Your ref: SSD-5544 Modification 7
Our ref: 12640825

Interim Audit Advice 1 – Ampol Kurnell Remedial Action Plan Review

AECOM, 2026. *Kurnell terminal SSD-5544 MOD-7, Appendix E – Remedial Action Plan*, Ref.60695088, Rev.4, 29 January 2026 – (the “RAP”).

**FIGURE F3:
FIRE WATER SYSTEM AND
OILY WATER SEWER**

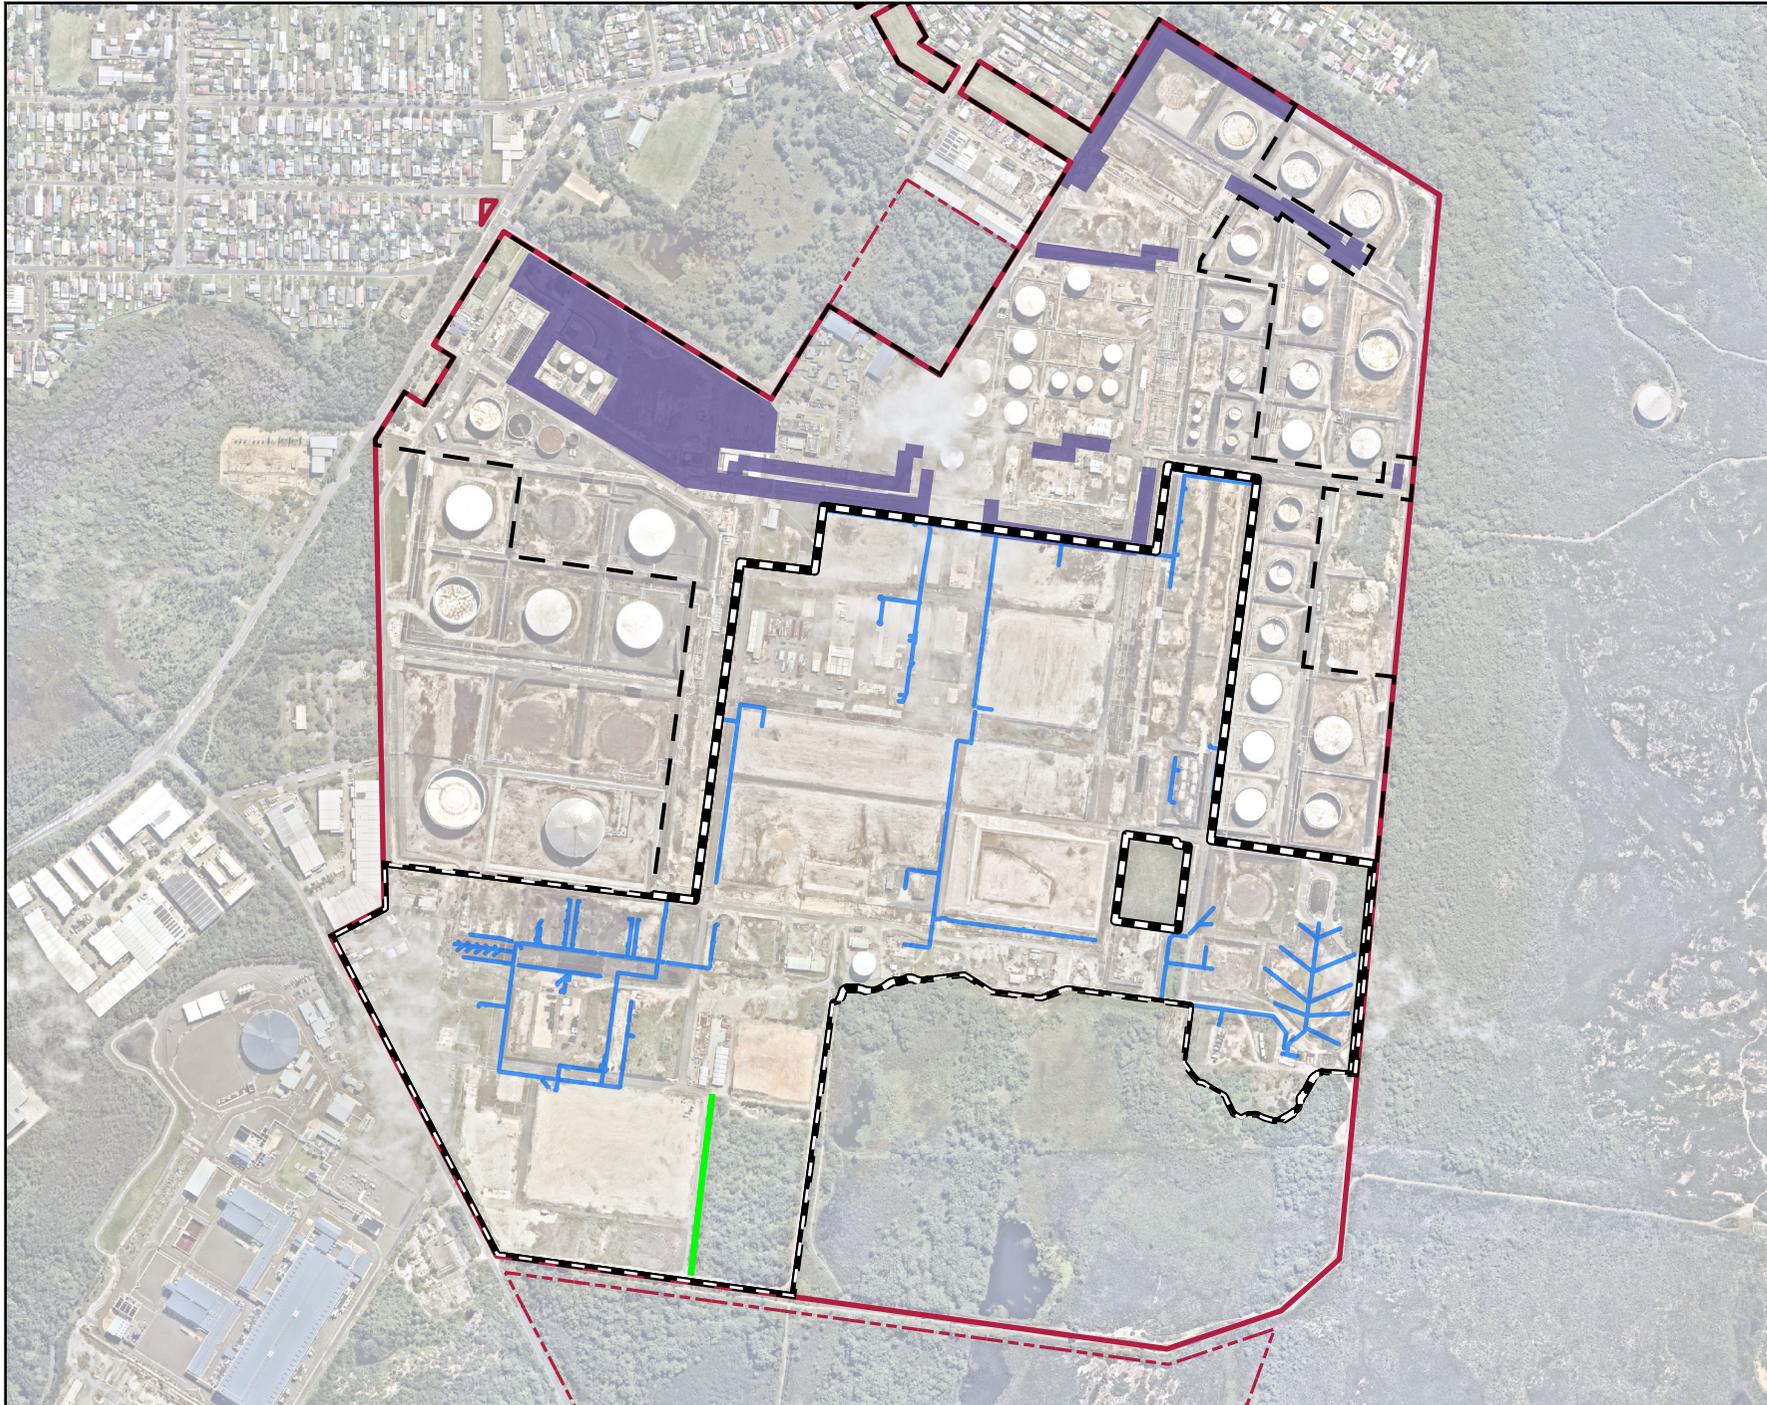
2	Executive Summary	Remediation objectives: What are "the" parts of the Project Area being referred to?	Text amended	Comment closed.	-	-
3	Executive Summary	Site Audit: The ACS cell should be identified in Figure F3.	Figure updated	Comment closed.	-	-
4	Executive Summary	Site understanding: PAHs can be petrogenic or pyrogenic. Please review.	Primarily petrogenic, but potentially pyrogenic in fill. No change	Comment addressed.	-	-
5	Executive Summary	Site understanding: Have all secondary COPC been identified on-site, or rather their potential presence based on historical use? This is an important distinction.	Text amended	Comment closed.	-	-
6	Executive Summary	Remediation overview: "Free phase LNAPL" - LNAPL is by definition free phase.	Text amended	Comment closed.	-	-
7	Executive Summary	Remediation overview: In the context of comments from the Department and previous audit comments, a more detailed consideration of the status of groundwater remediation in the summary should be presented.	Text amended	Comment closed.	-	-
